Subject: FW: 1120 Fleurie Nursery - Lake Lane WA/16/21/DOC

Further to the submission of additional information contained in Landscape Plans 1120-007a and 1120-008a, I can confirm that the applicant has provided plant number/species mix details and that the information submitted is now sufficient to recommend the discharge of Condition 9 on application WA/16/21/DOC.

PROPOSED
Landscape Plan
1120 - 010
February 2021
1500 @A3

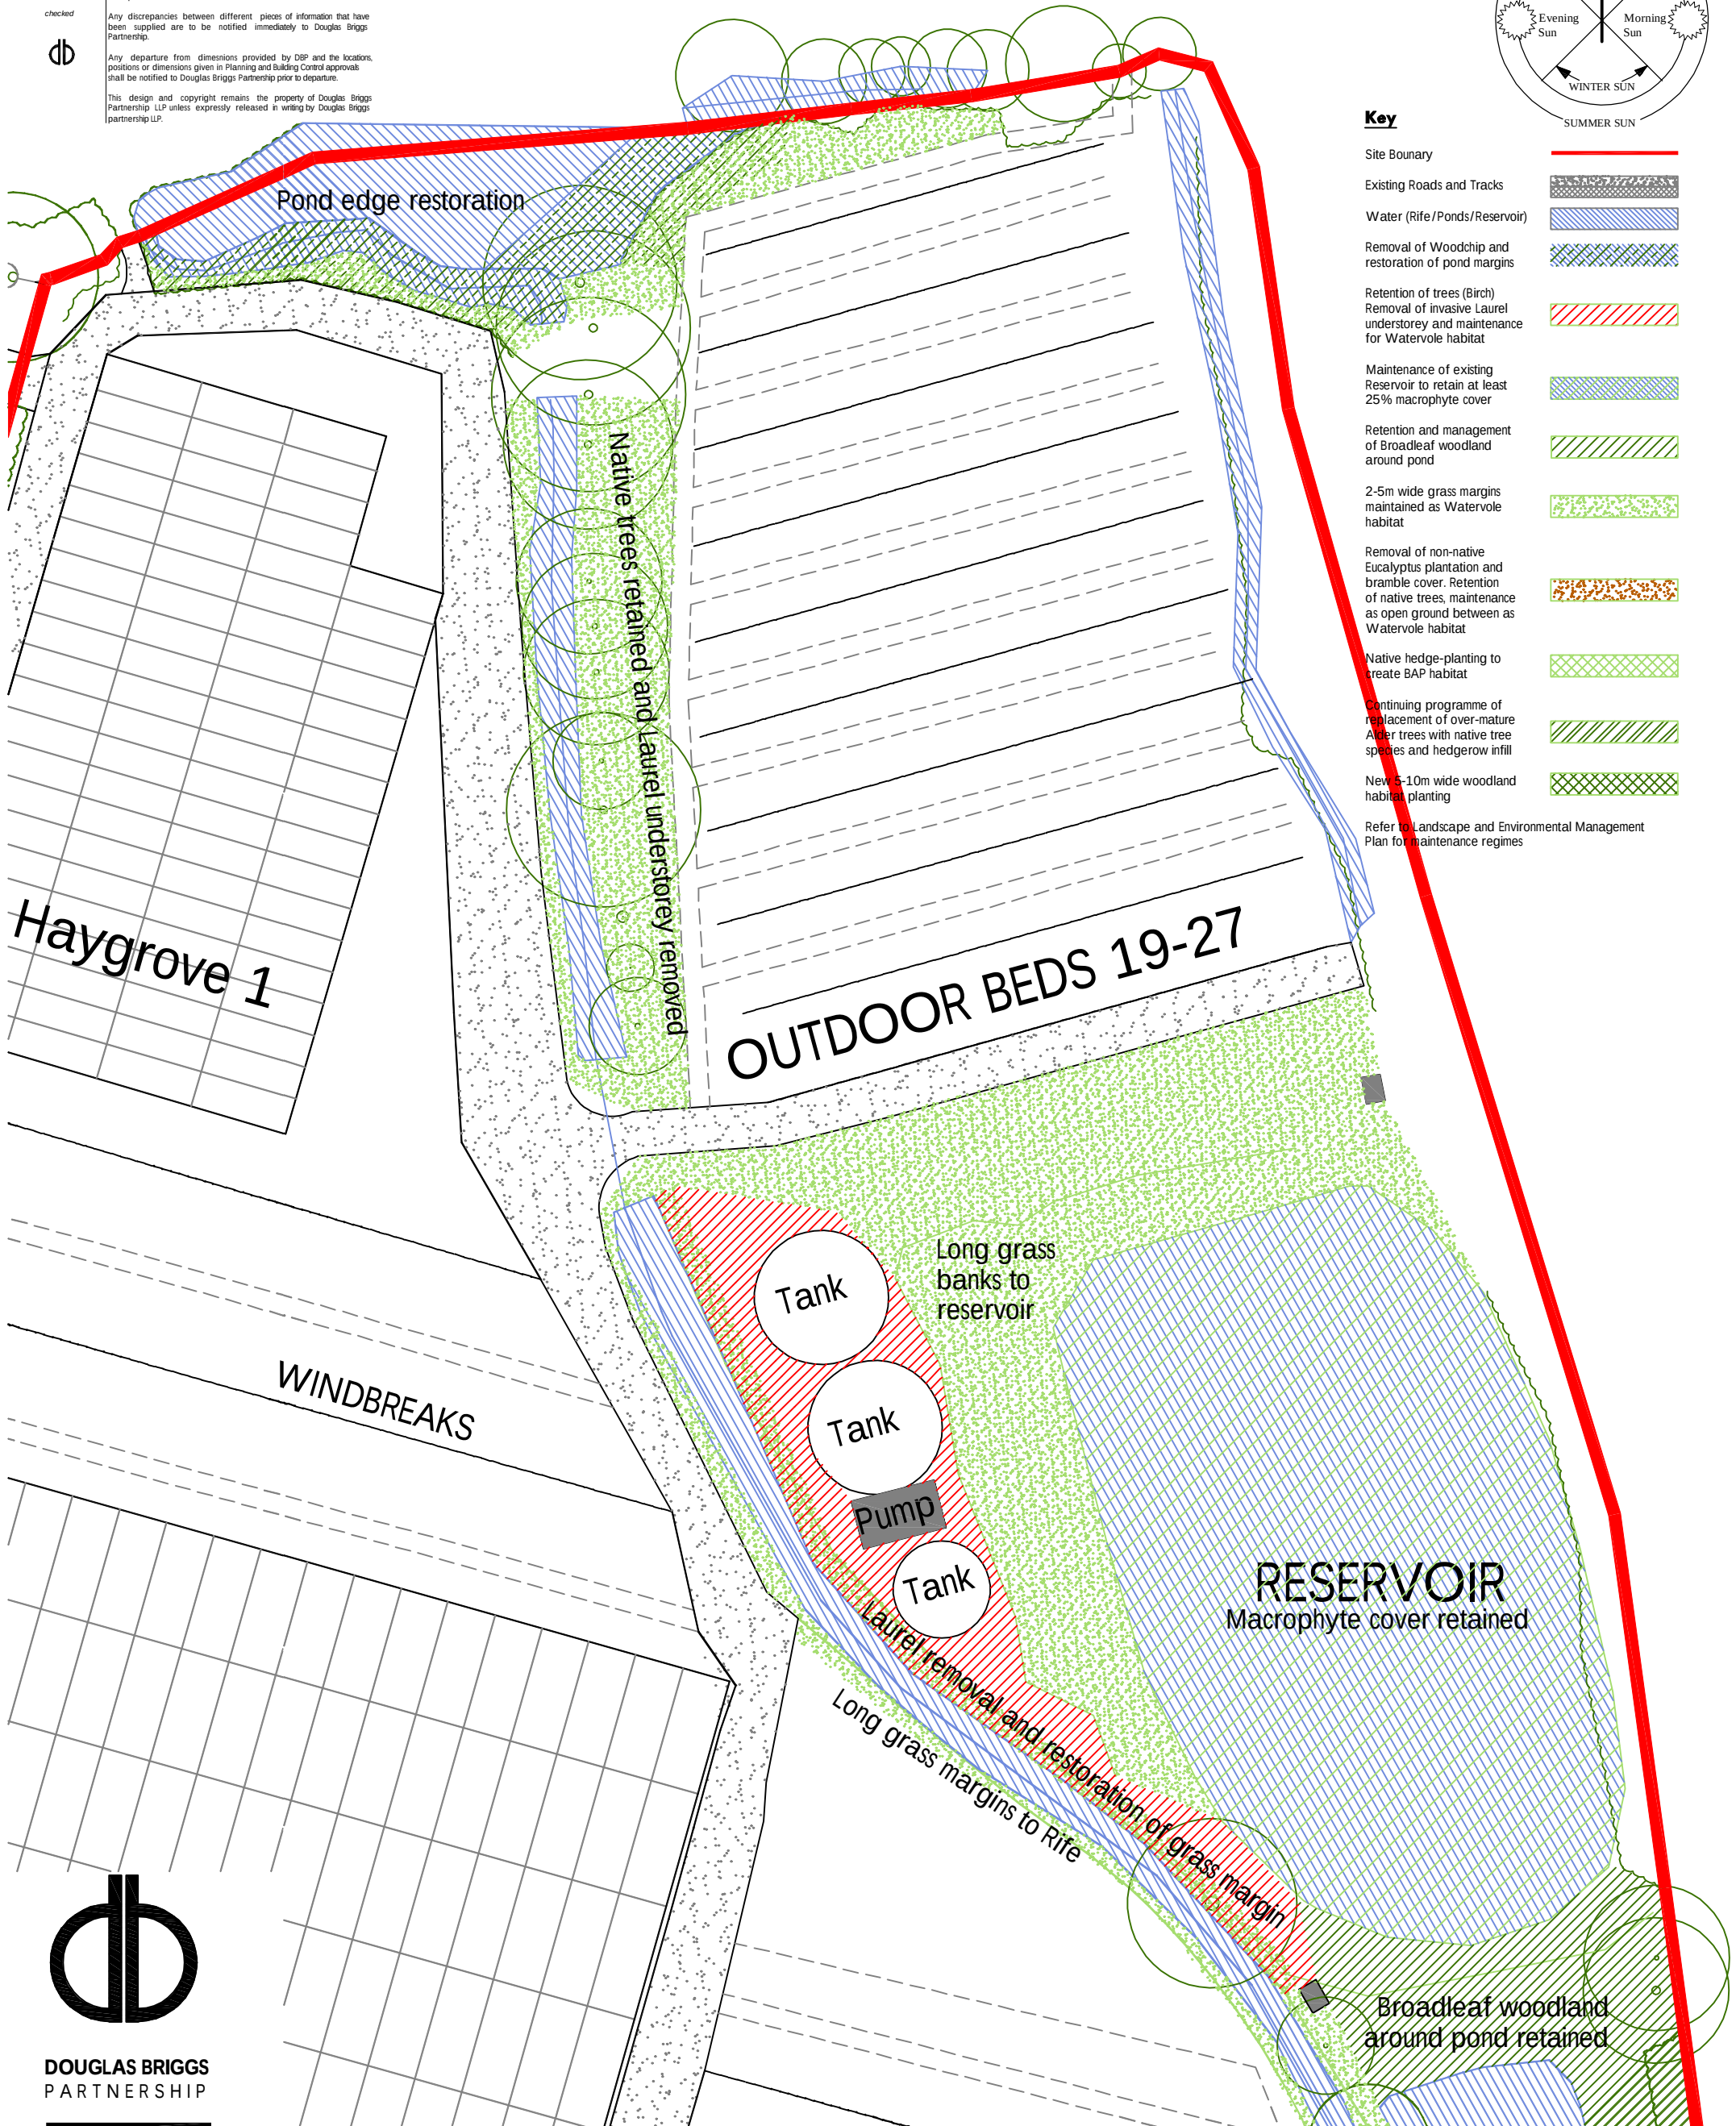
The information has provided further clarity, but in order to be able to recommend discharge of Condition 9, detail in plan form re quantities still needs to be provided. ie actual quantities for the

new hedges (appreciate more difficult to show for the gapping up) The information also needs to be shown in plan form ie plant numbers in location. (see extract from consultation below)

Further detail is requested to confirm the plant quantities for these areas and anticipated gapping up numbers. The detail is required to be shown on the submitted drawings and needs to show clearly quantities, species mix i.e. percentage of each within the species mix, planting densities (anticipated in gapping areas) and size of plants at time of planting.

Further to your e-mail to the applicant, the quantities of planting to be used in each area have been shown on the attached drawings as requested.
